From: Chima Umunnakwe <Chima.Umunnakwe@arun.gov.uk>
Sent: 02 December 2021 19:27
To: Planning.Responses <Planning.Responses@arun.gov.uk>
Cc: Anita Gardner <Anita.Gardner@arun.gov.uk>
Subject: LU/338/21/PL

Thank you for consulting Environmental Health on the above application. I have considered the proposed scheme and can advise any approval considered be given the following consideration and where appropriate conditions recommended.

5.2 Lighting Strategy

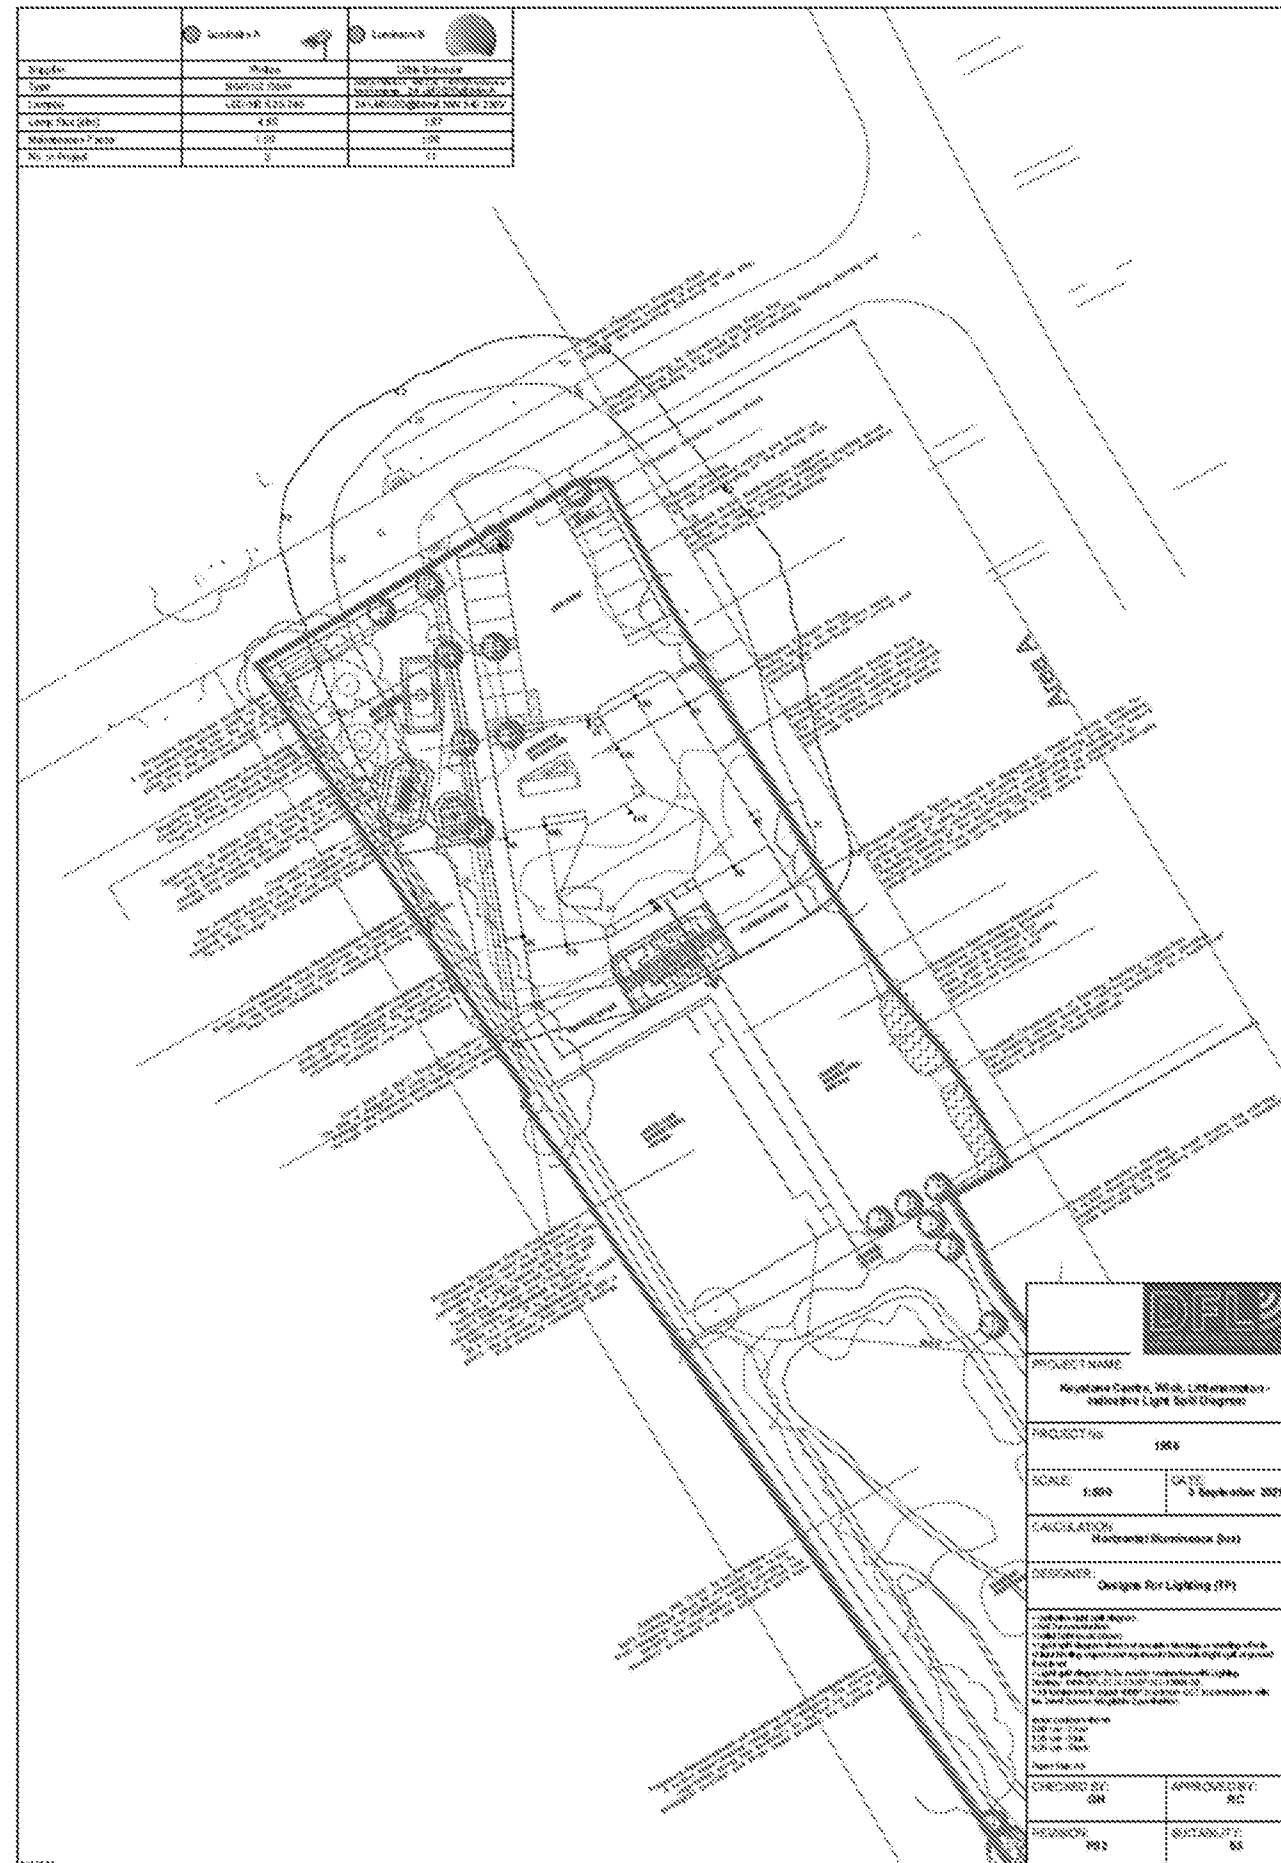
The applicant has provided a lighting strategy. However, EH advised that the proposed lighting be installed in such a manner to prevent obstructive light to avoid light nuisance at nearby light-sensitive receptors. All installation of lighting luminaires should reference the guidance given by the Institute of Lighting Professional to ensure that existing residents are protected from obstructive lightings.
